**Re: Cottonwood Crossing II Lots 2A & 2B at 10088 and 10080 Coors Blvd SE
Erosion and Sediment Control Plan
Engineer's Stamp Date 9/25/24 (B14E010D)**

Based on the information in your submittal, received on 12/3/24, the ESC Plan and NOI are satisfactory for the current disturbance, but they cannot be approved for any further land disturbance until the following comments are addressed. In the meantime, please post your permit coverage, install BMPs, and ensure your SWPPP and self-inspection reports are up-to-date and available onsite throughout construction. You must resubmit your ESC Plan to address the following comments before any new land disturbance.

James D. Hughes, P.E. CPESC.
Principal Engineer, Planning Dept.
Development and Review Service

EROSION CONTROL PLAN

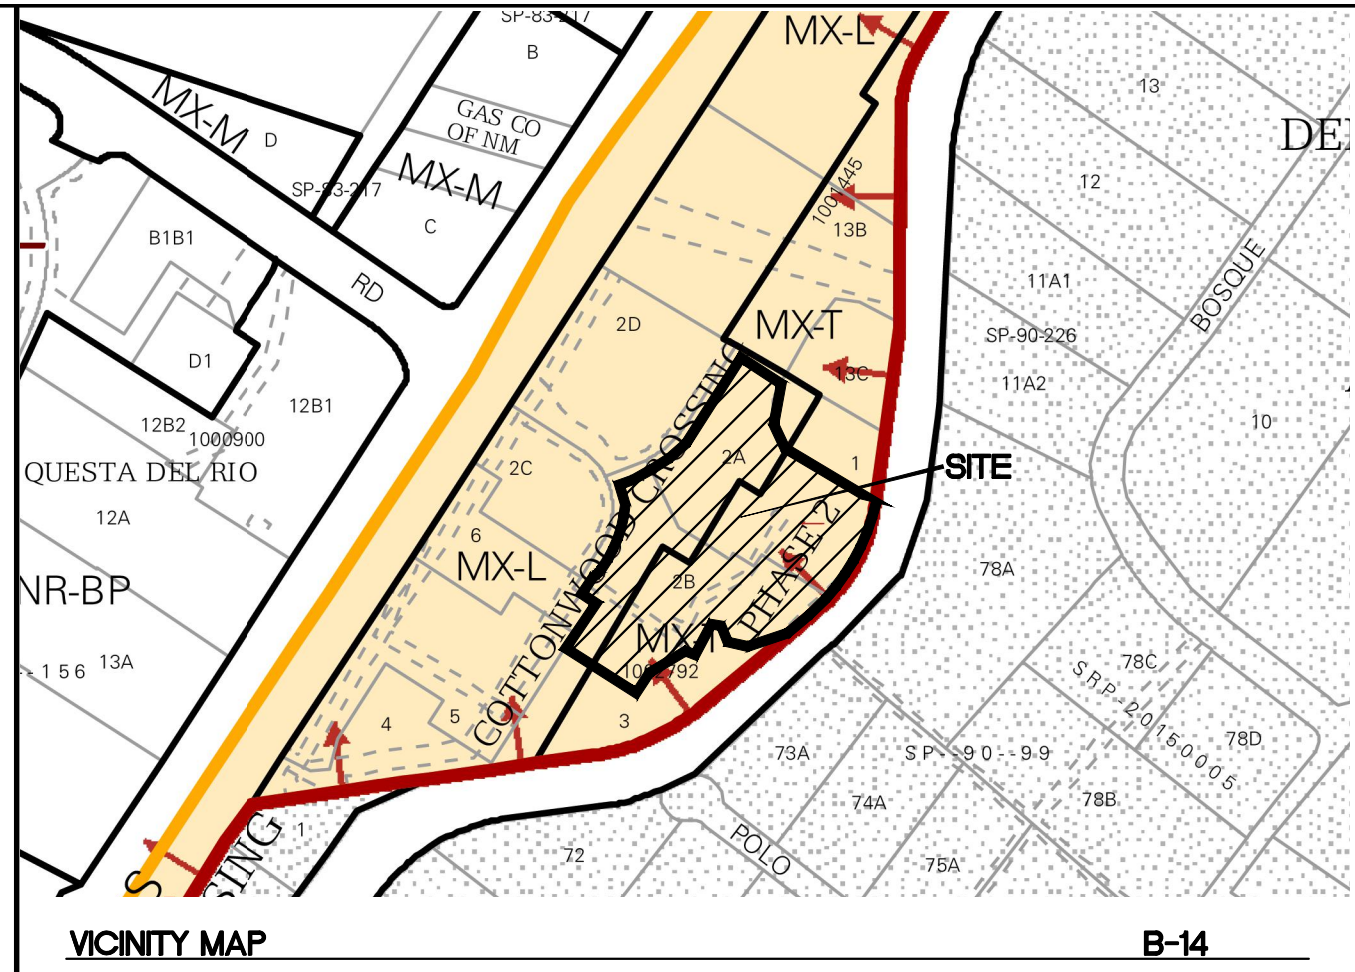
3. The swale that you added to divert offsite drainage to the offsite inlet southwest of this site crosses Popeyes' existing paved parking lot, and there aren't any details of the diversion in the ESC Plan or grading plans.

4. The initial BMPs should be constructed so they can be maintained and don't interfere with Phase 1 construction, presumably the road and utilities. It appears that the road in front of the townhomes will be constructed under a Work Order as Phase 1 since lot lines are shown between the townhomes and the road is separated from the lots by a property line. However, Phase 1 construction may start with buildings if the lot lines are removed and the townhomes are developed as condominiums or apartments. The DFT approval of a Site Plan and Infrastructure List will determine the construction sequence and phasing.

5. If the road work is Phase 1, then Phase 2 will start after stormwater runoff from the offsite portions of the watershed has been conveyed in a non-erosive, lined drainage system consisting

of paving, C&G, and storm drain. During Phase 2, the sediment trap(s) will be removed, and a silt fence will be added around the low sides of the lots to prevent sediment and pollutants from entering the lined conveyance system. The silt fence must be "on contour" with the ends turning uphill. Additional berms and ponds will be necessary for any concentrated discharge points into the lined system.

6. New ESC Plans must be submitted to the city for any lots transferred to new owners/operators.
7. If the rear yards of the townhouse lots drain to the AMAFCA Pond, temporary stormwater controls need to be added to control that discharge during both phases.
